Ribble Valley Borough Council
Housing & Development Control

Application no: **3/2021/1042**

Address: **Land to the rear of 16 Whiteacre Lane Barrow BB7 9BJ**

Proposal: **Proposed erection of one new, two-storey, three-bedroom dwelling. Resubmission of 3/2020/0677.**

<b>NICK WILKINSON TECHNICAL SURVEYOR LIMITED</b>				
client	MR & MRS HINDLE			
project	SITE SOUTH OF 16 WHITEACRE LANE			
drawing	AS PROPOSED			
date	03_05_22	scale	1:100.	checked
job no	001	drawing no.	AL(2-)01	rev. 02

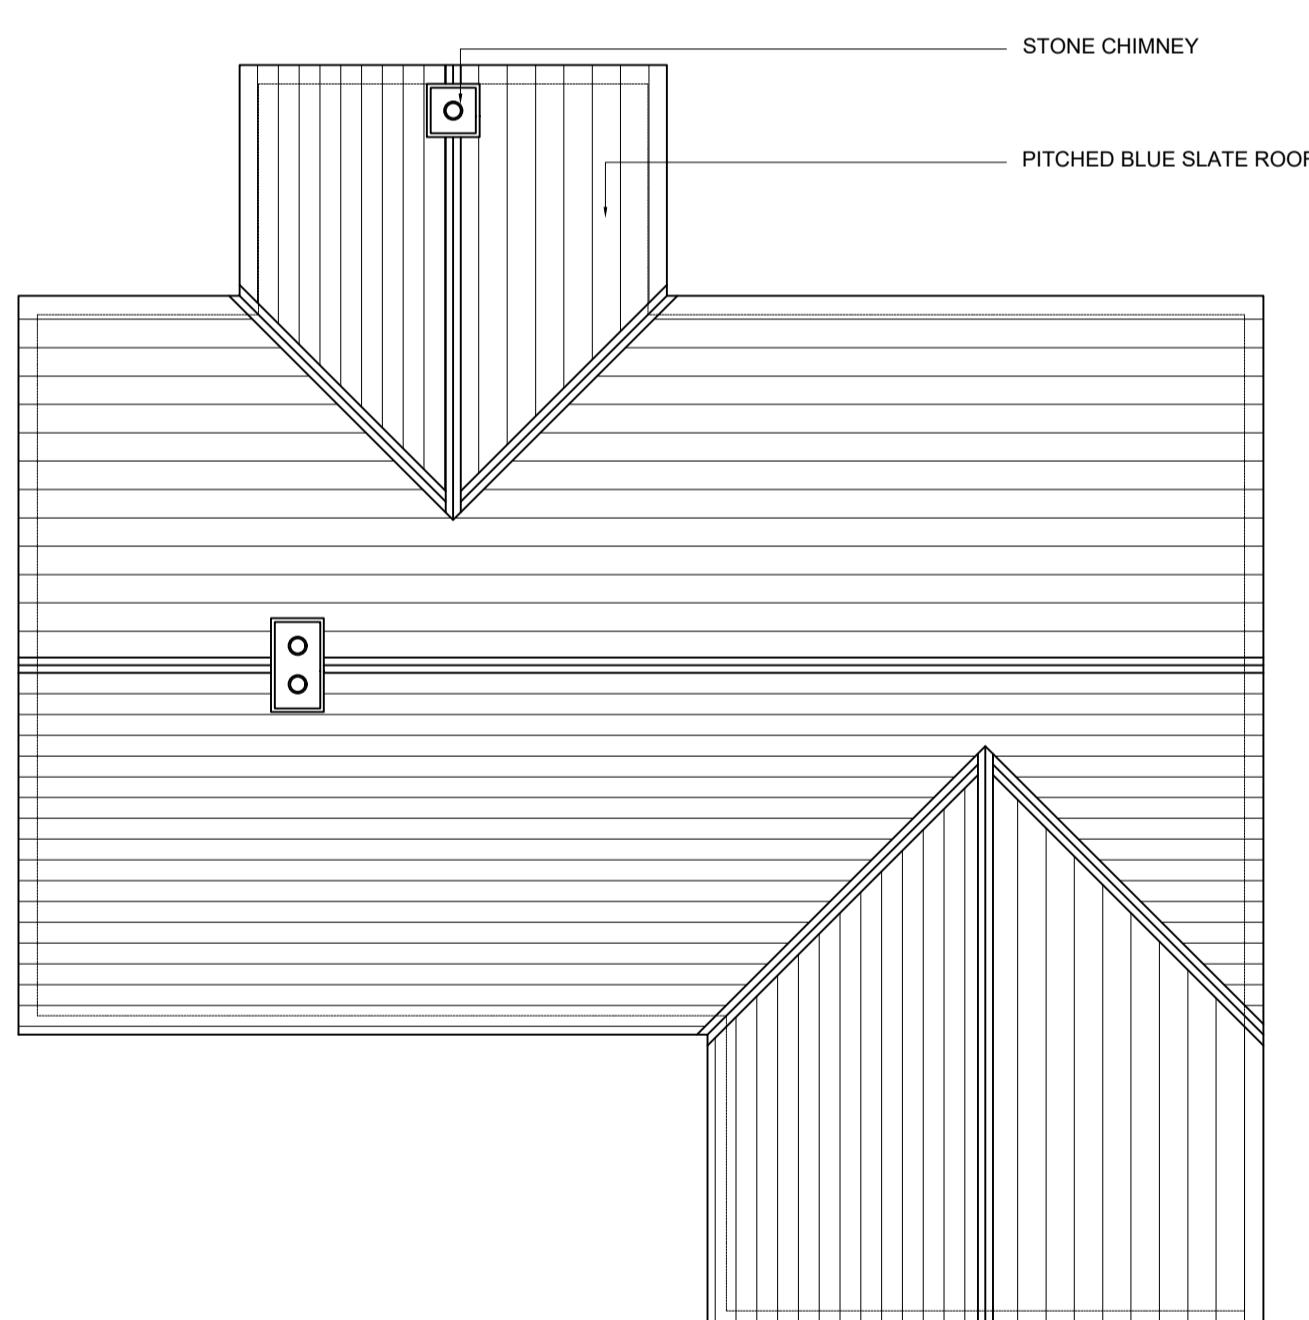
The LHA have reviewed Nick Wilkinson drawing number AL(2-)01 Rev 003 titled "Proposed Site Layout" and are satisfied that the parking arrangements complies with the LHAs guidance as defined in the Joint Lancashire Structure Plan. Therefore, the LHA have no objection to the proposal.

1.No part of the development hereby permitted shall be occupied until such time as the access arrangements shown on Nick Wilkinson drawing number AL (2-)01 Rev 003 have been implemented in full.

2. The development hereby permitted shall not be occupied until such time as the parking and turning facilities have been implemented in accordance with Nick Wilkinson drawing number AL (2-)01 Rev 003. Thereafter the onsite parking provision shall be so maintained in perpetuity.
